THE PADDINGTON SOCIETY INC
FOR COMMUNITY AND HERITAGE
EST 1964

OBJECTIONS including 5 Appendices

TO 142-148, 160 OXFORD ST, 13 GIPPS ST, 6 SHADFORTH ST STATE SIGNIFICANT DEVELOPMENT SSD 97528708

Figure 19 Diagram showing trafficable roof terraces setback from the building parapet to mitigate overlooking from proposed height variation

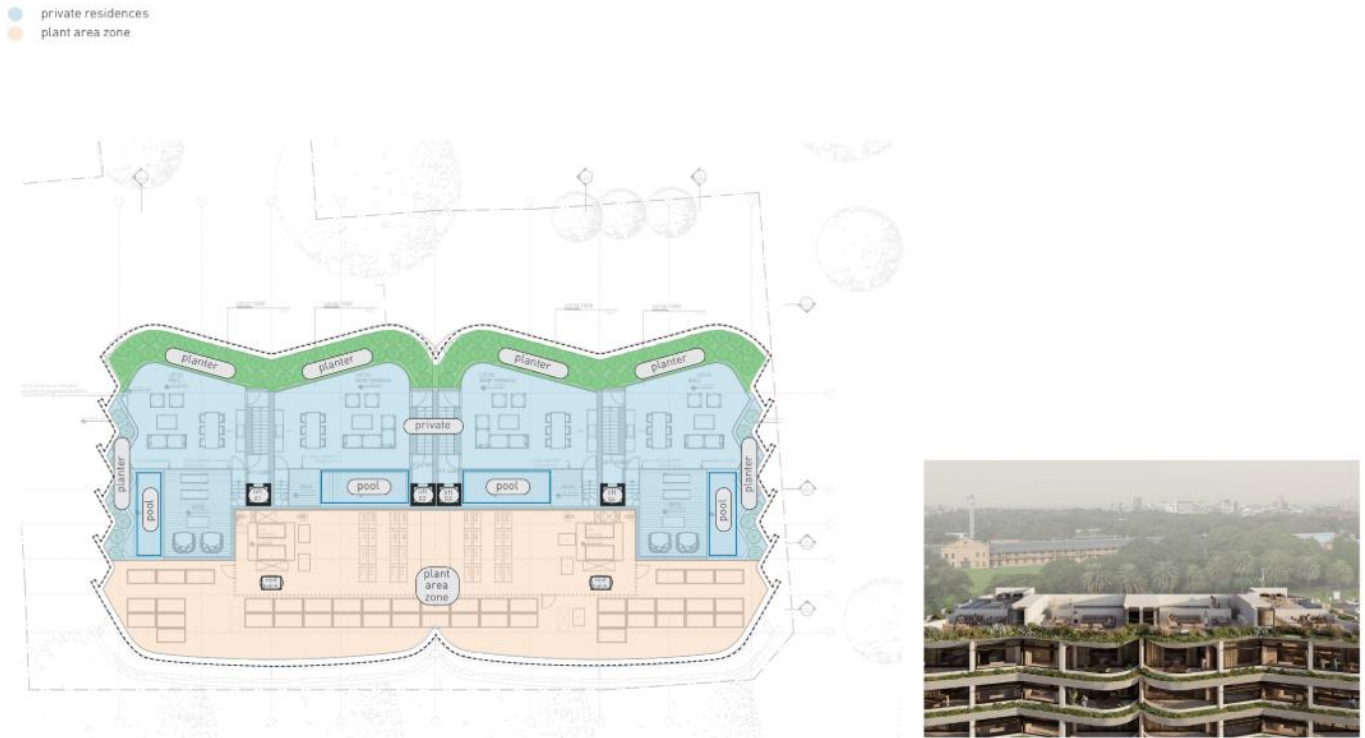
- Consideration of separation distances for **neighbour privacy** the Apartment Design Guide (ADG) is mandatory, and especially important in this tight urban landscape. Yet, the separation between proposed balconies and the POS of 8 Shadforth St and 23-27 Gipps St is only 9.8m (p. 62 Design Report) and should be 21m. (18m + 3m for change of zone.) 10-12 Shadforth St will all have a less than 21m separation of proposed balconies to Private Open Spaces. Similarly, separation between balconies and windows of 5-7 Shadforth St is only 13m, and should be 21m. The applicant's claim

that solid balustrades mitigate **privacy** concerns is NOT valid as the 1m balustrade height does not preclude overlooking.

Figure 23 Overshadowing diagrams showing impact to Victoria Barracks

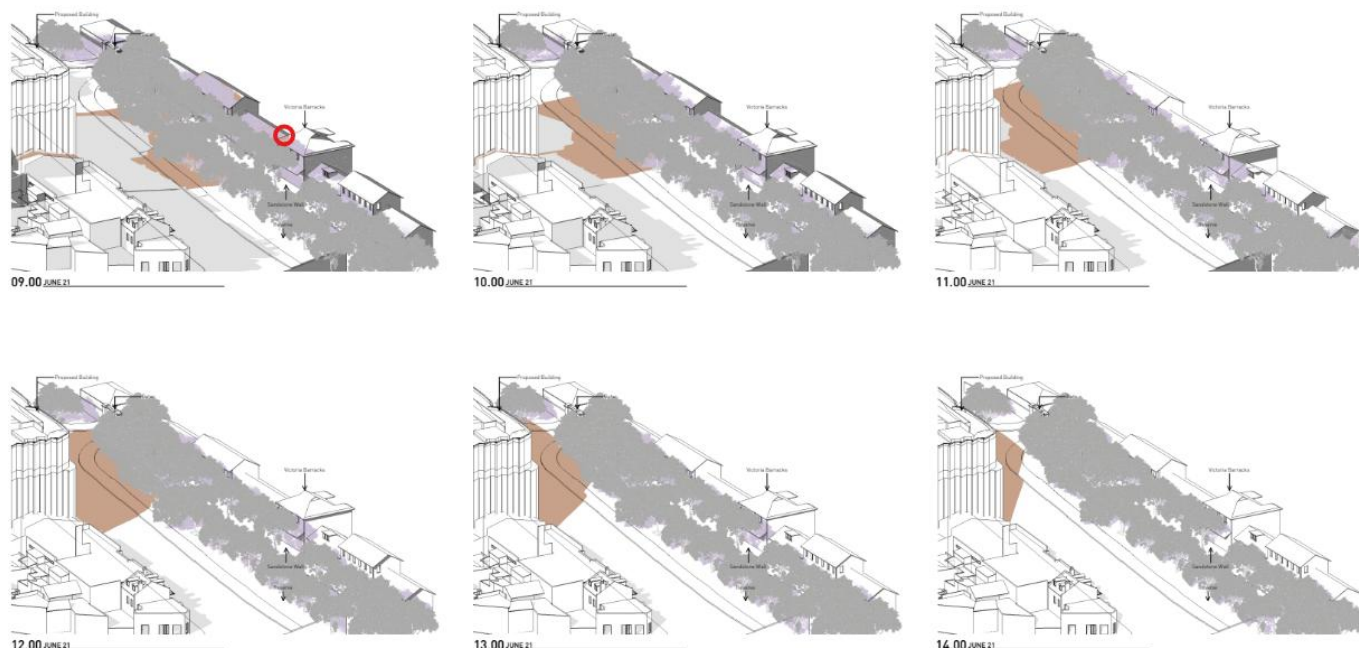
- Winter **solar access** from 9am to noon will be lost to Oxford St Reserve and the walls to Victoria Barracks – thus diminishing the Barracks’ heritage significance and the public’s enjoyment of the Reserve, a popular seating spot in winter.
- **Traffic:** the movement of 83 cars in and out of the proposed units into narrow Shadforth St (12 houses) will cause a large upswing in noise, lights, and congestion which will reduce the livability for the current residents. In addition, the applicant advises that construction trucks (30/day for 26+ months) will need to access the site via narrow Glenmore Rd, Liverpool and Shadforth Streets– causing intense congestion to an extensive area of the HCA, including “The Intersection” retail.
- We ask that this and other objections can be raised in a **Public Hearing** in front of the Independent Planning Commission, to allow the community a voice.
